RE: JLM Living Paseo Traffic Impact Study (C10D003), DRAFT July 2024
Response to Comments dated August 19, 2024

This letter serves as a response to your comments addressed to Jonathan Kruse, PE of Lee Engineering dated August 19, 2024 regarding the review of the July 2024 JLM Living Paseo Traffic Impact Study draft. Mr. Kruse deferred your comments to me as the Engineer of Record for development of this project. I have copied your comments from your letter, inserted them below and written responses that indicate changes for the final report.

Figure 2: Site Plan

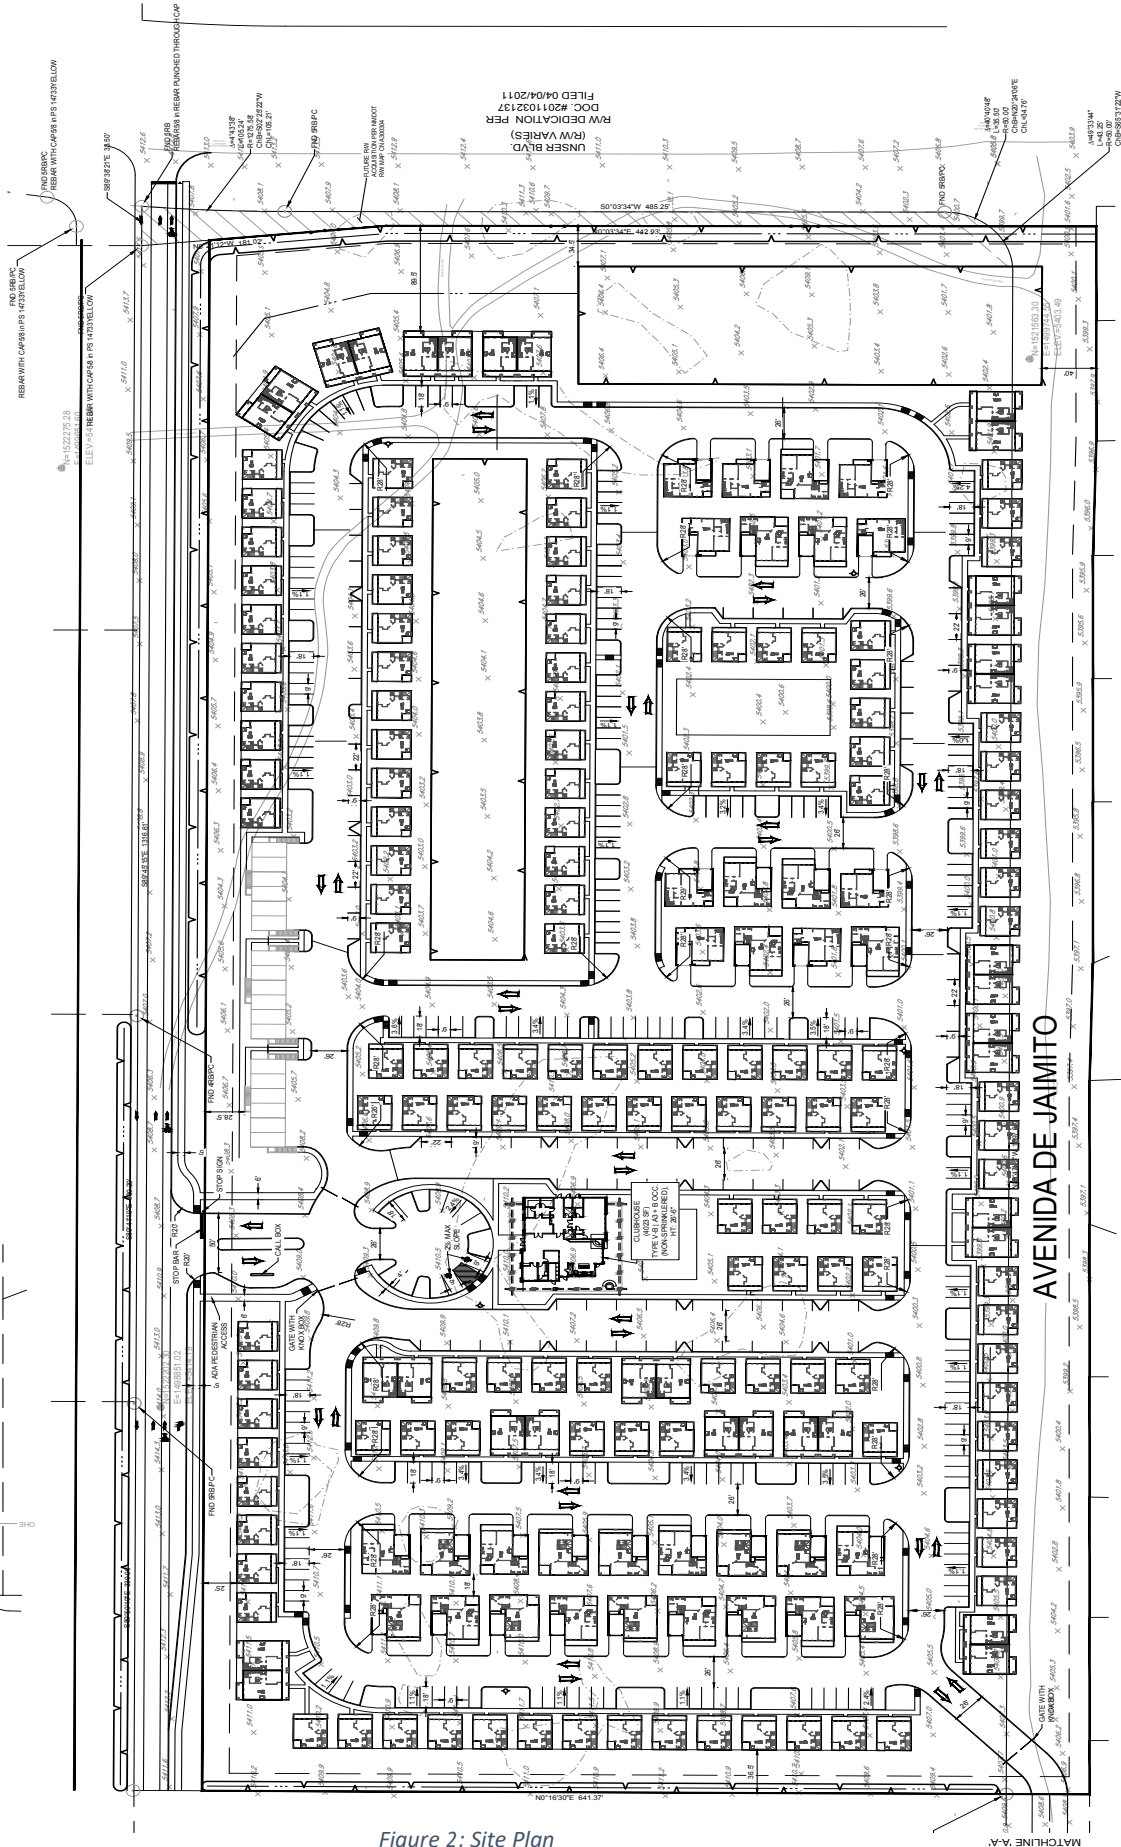
2. Comment: *Revise the Site Plan to include (1) Ave De Jaimito from Universe Blvd to the site and (2) Unser Blvd.*

Please revise the Site Plan and add the construction of Woodmont Blvd, including extents, to the Site Recommendations.

Response: A revised site plan is included in the Final Traffic Impact Study showing these two streets and access points as requested.

Response: Addressed in revised document.
